Mr Brendon Roberts
Team Leader
Key Sites Assessments
Department of Planning and Environment
GPO Box 39
Sydney NSW 2001

**Redevelopment of Harbourside Shopping Centre, Darling Harbour
Notice of Exhibition (SSD 7874)**

Margaret Prendergast 23.2.17
Coordinator General
CBD Coordination Office

Image 127 Basement access, and Darling Drive drop off locations

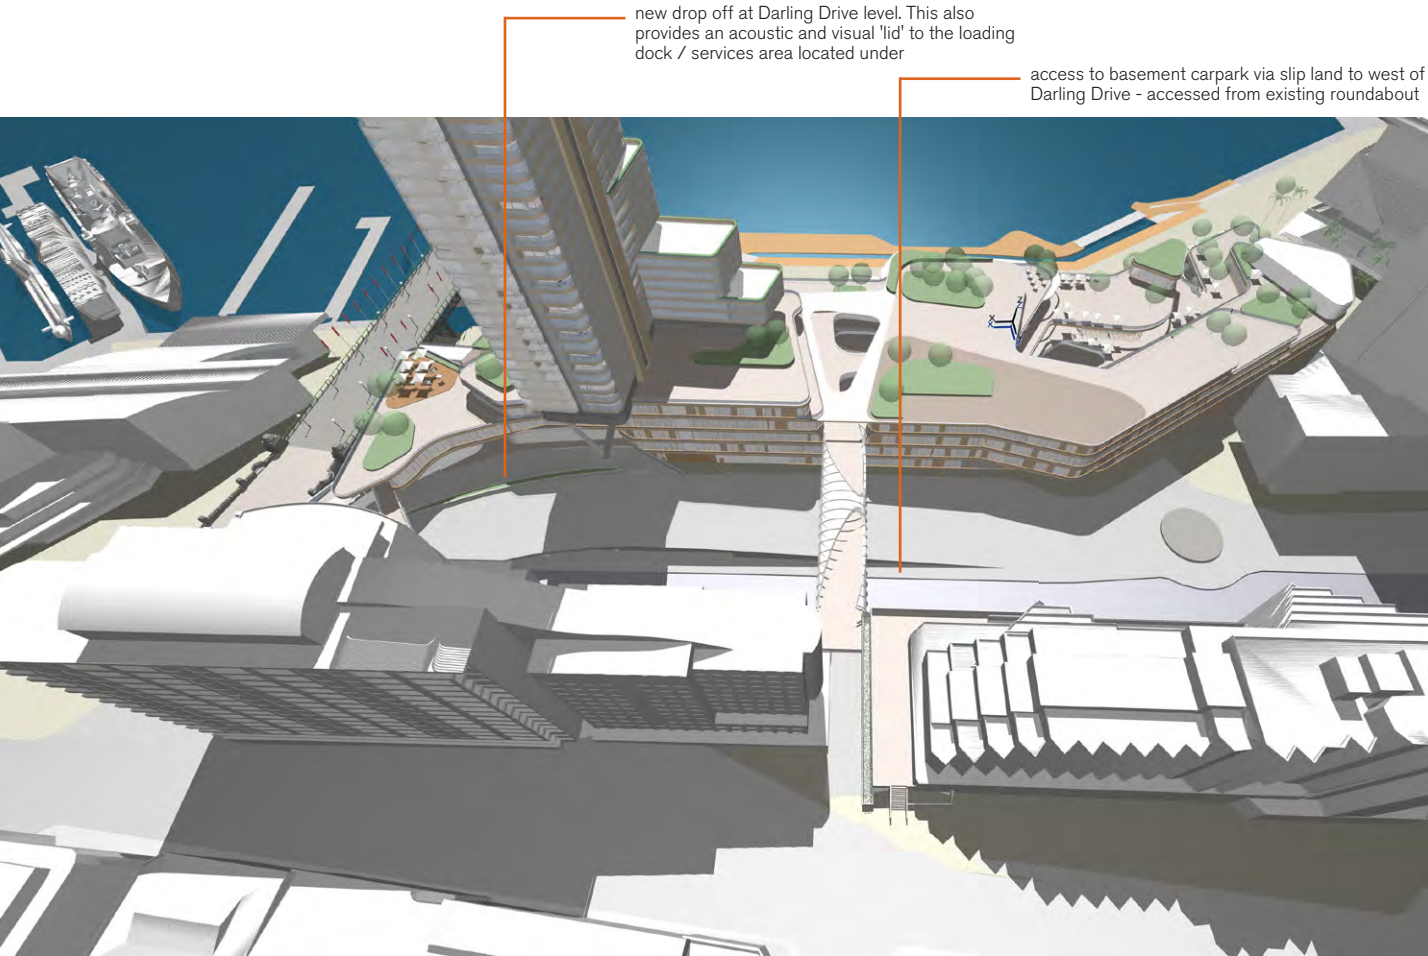
The proposed development is situated on Darling Drive which is a key route within the CBD. The Traffic and Transport Impact Assessment (Traffic Report) prepared to support the development application does not state the likely demand for the drop-off zone in Darling Drive. The vehicles queuing to access this drop off zone may cause delays and block vehicles on Darling Drive. In addition, any queuing due to vehicles accessing the car park and loading and servicing area may also cause delays and block vehicles on Darling Drive.

TfNSW requests that the applicant undertakes a detailed queuing analysis to identify the risks associated with the queuing on public roads and proposes mitigation measures to the satisfaction of the CBD Coordination Office within TfNSW and Roads and Maritime Services.

The proposed development has a frontage on Darling Drive, which forms part of the strategic cycleway network in the CBD. TfNSW advises that the design for the vehicular drop-off zone should take into consideration the future use of Darling Drive with the cycleway.

Figure 4.6.2 Entry to podium at south end of site (ground floor)

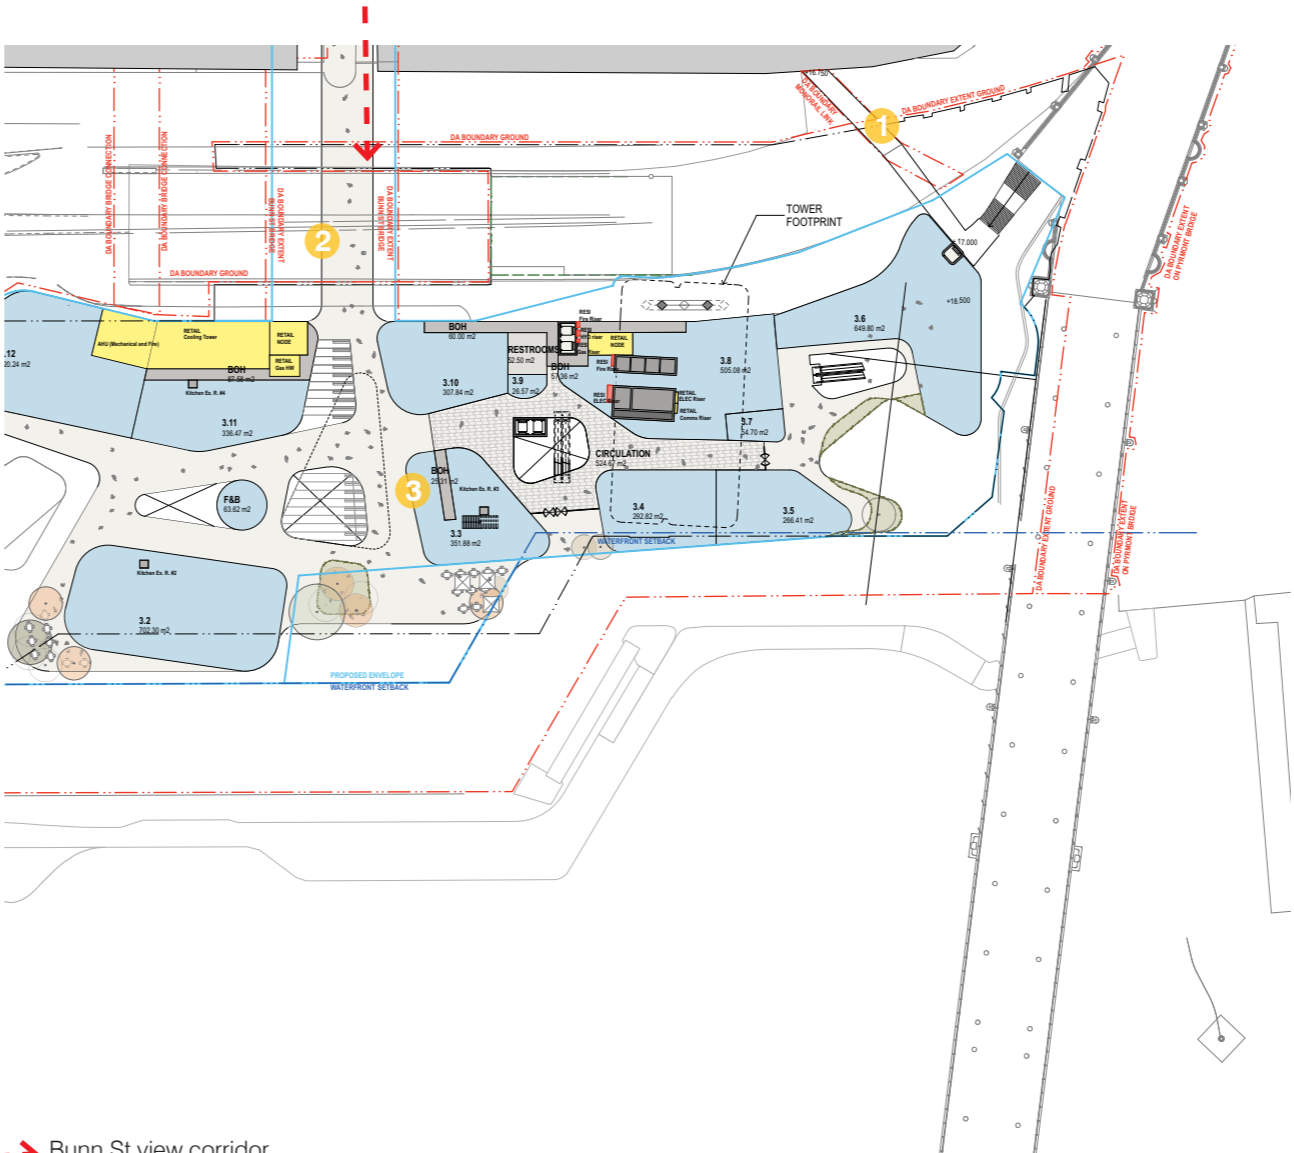
There are a number of construction and operational issues resulting from the demolition existing pedestrian footbridge from the Harbourside car park across the light rail corridor at Convention stop and the construction of the Bunn Street footbridge across the light rail corridor north of Convention stop. It is also noted that the proposed construction activities are likely to interfere with the light rail operation. TfNSW requests that ongoing consultation is required between the applicant, TfNSW, light rail operator, and if required, Sydney Trains during the design and construction of the proposed development.

- It is advised that demolition of the existing of the existing footbridge from the Harbourside car park and the construction of the new bridge will invariably require shutdowns. TfNSW requires information on timing and construction methodology of these structures in particular in situ or pre-cast construction; and
- The design and construction of the development must comply with ASA standard relating to external developments (T HR CI 12080 ST).
